HINCKLEY NATIONAL RAIL FREIGHT INTERCHANGE – LAND WEST OF STONEY STANTON

FINAL COMMENTS ON APPLICANT'S SUBMISSIONS

TECHNICAL NOTE

Review of DCO Transport Assessment following the Deadline 5, 6 and 7 submissions.

- 1.24 Overall, it is considered that that the measures proposed both within Sapcote and Stoney Stanton do not address the impact of the development within these settlements and that the residual overall cumulative impact will be severe in the context of paragraph 115 of the NPPF (December 2023).

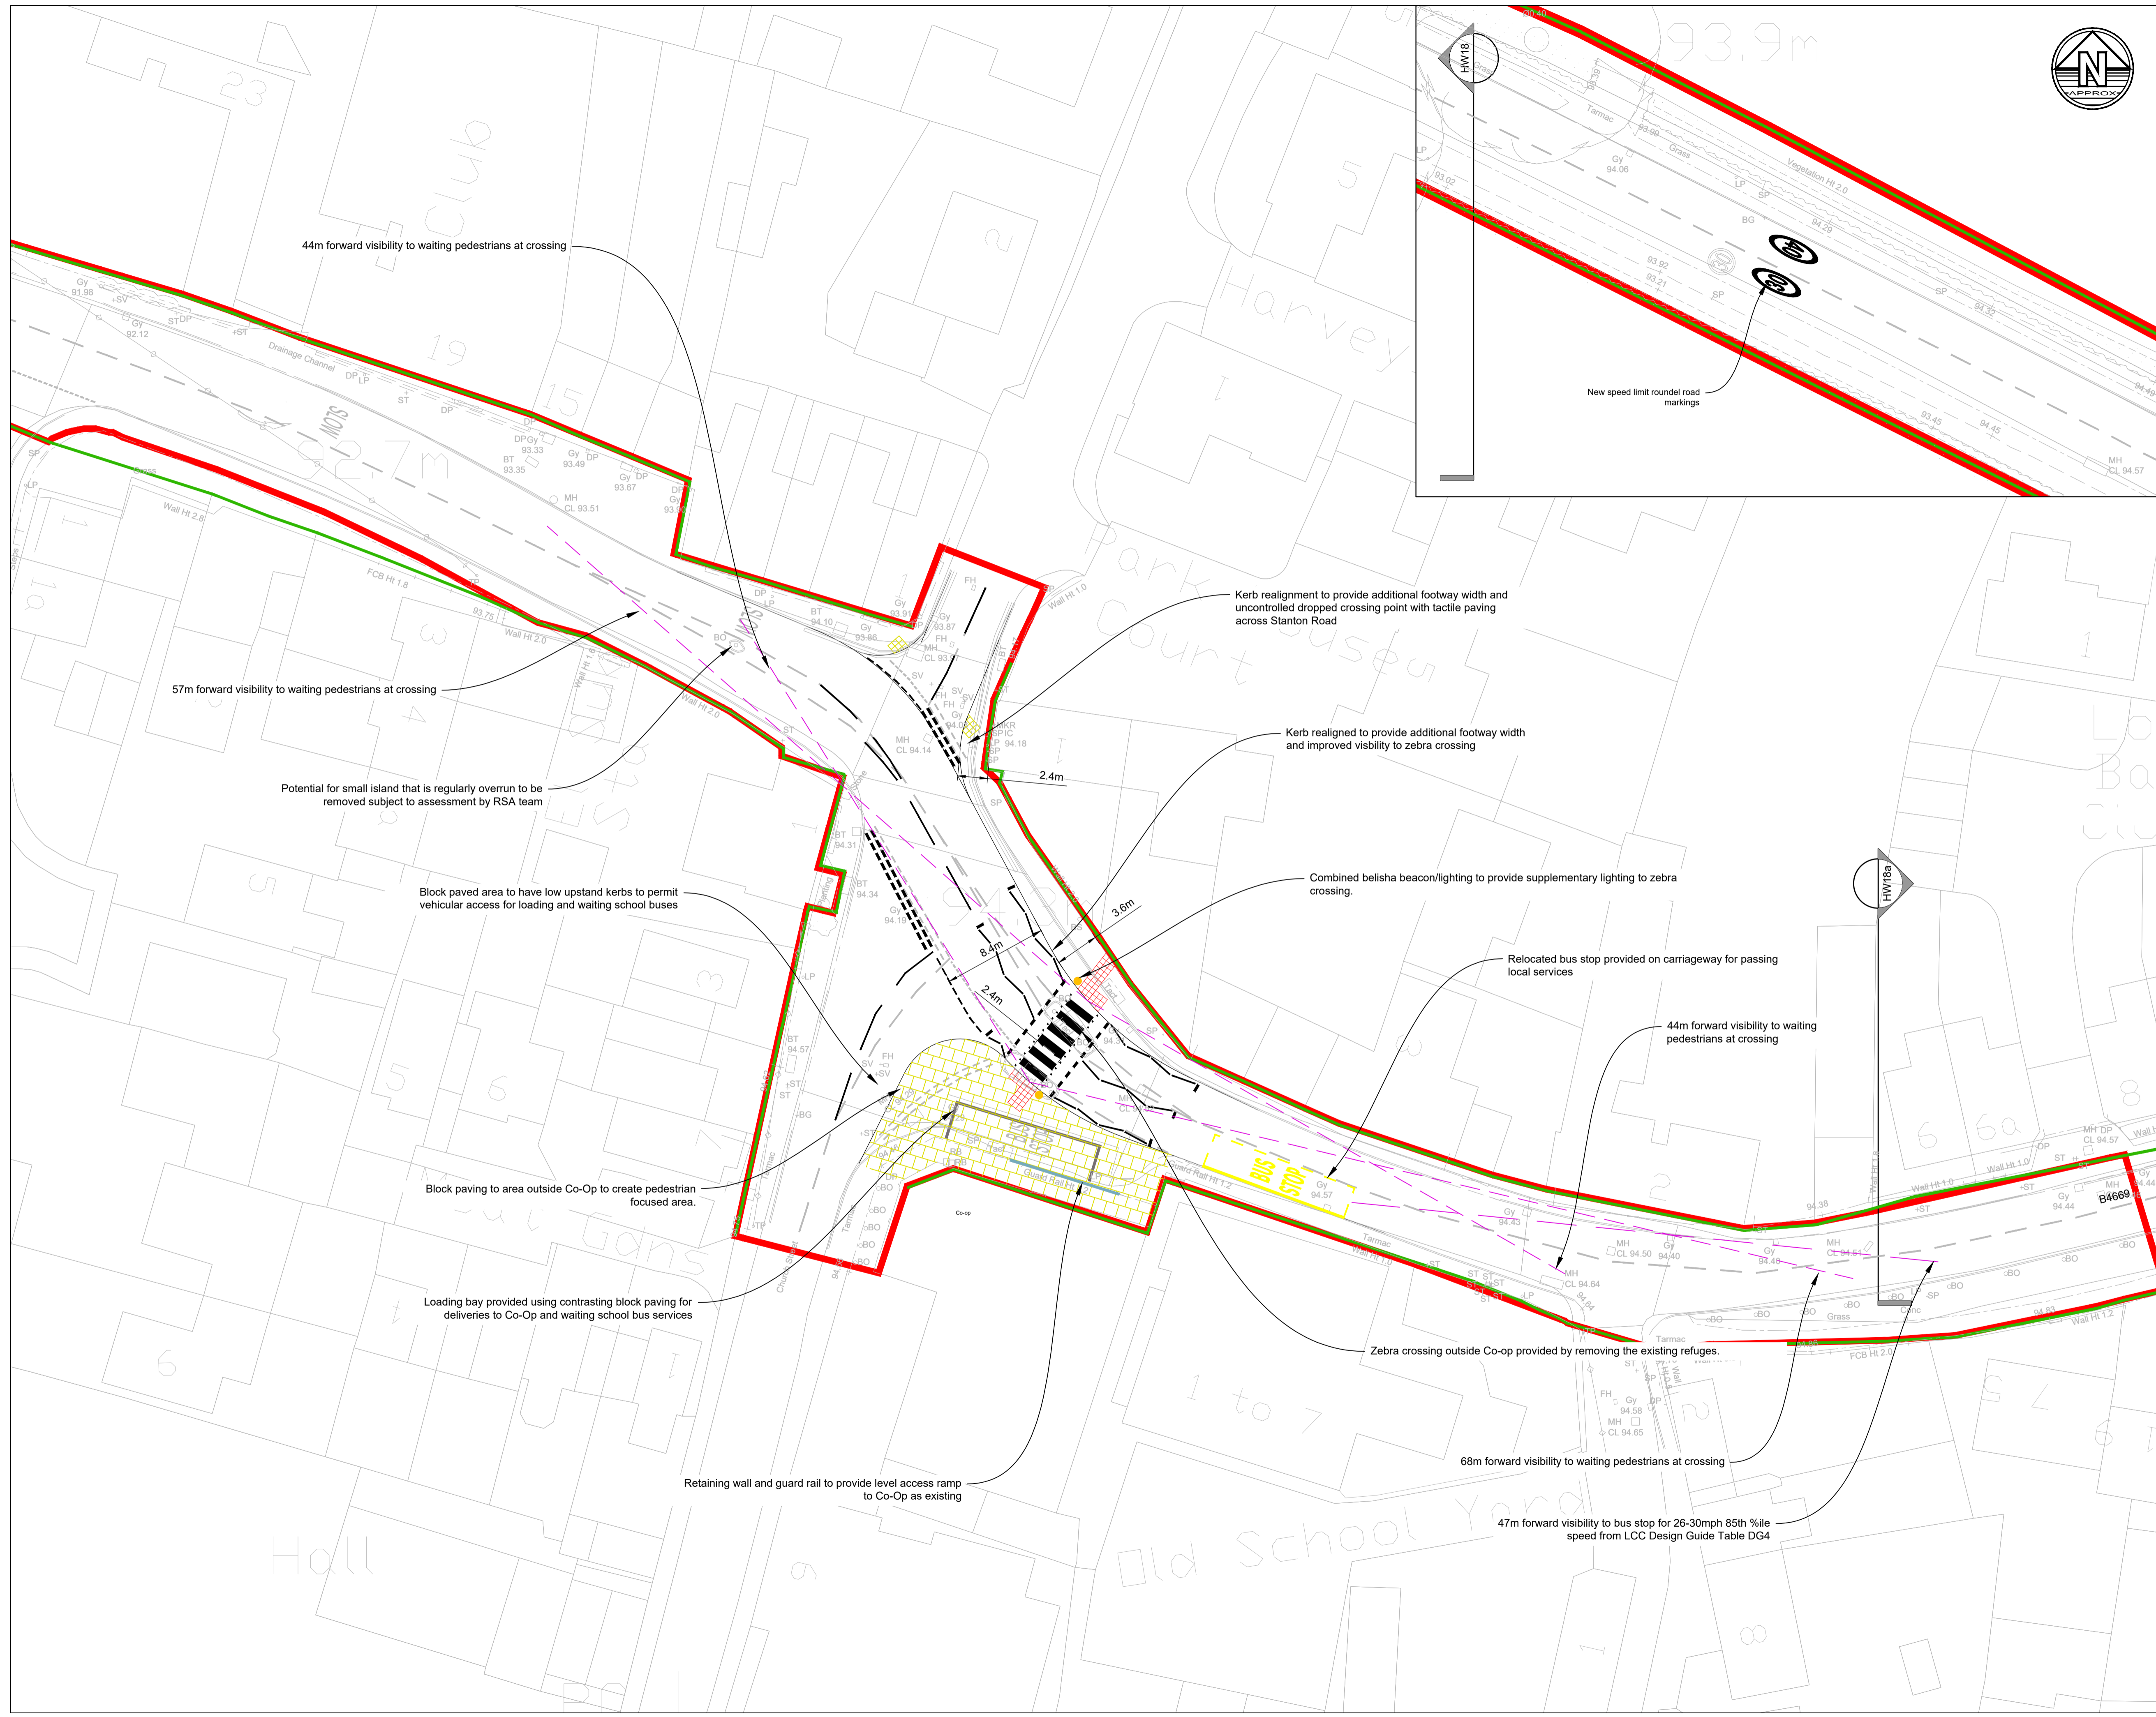
1.12 In the context of the impact of the HNRFI development on Sapcote, it is clear that the measure proposed for Sapcote are not acceptable in terms of Road Safety. This has been confirmed by LCC in their evidence and LCC do not accept the designer's response to the issues raised within the RSA. In practice the measures proposed by HNRFI offer limited benefit to Sapcote when set against the increase in traffic passing through this settlement as a consequence of the DCO application including the works to the M69 junction 2.

- 1.23 In relation to the Road Safety Audits undertaken, it is clear that the measures proposed for Sapcote and Stoney Stanton are not acceptable in terms of road safety. The measures proposed offer limited benefit to Sapcote and Stoney Stanton when set against the increase in traffic passing through these settlements as a consequence of the DCO application.
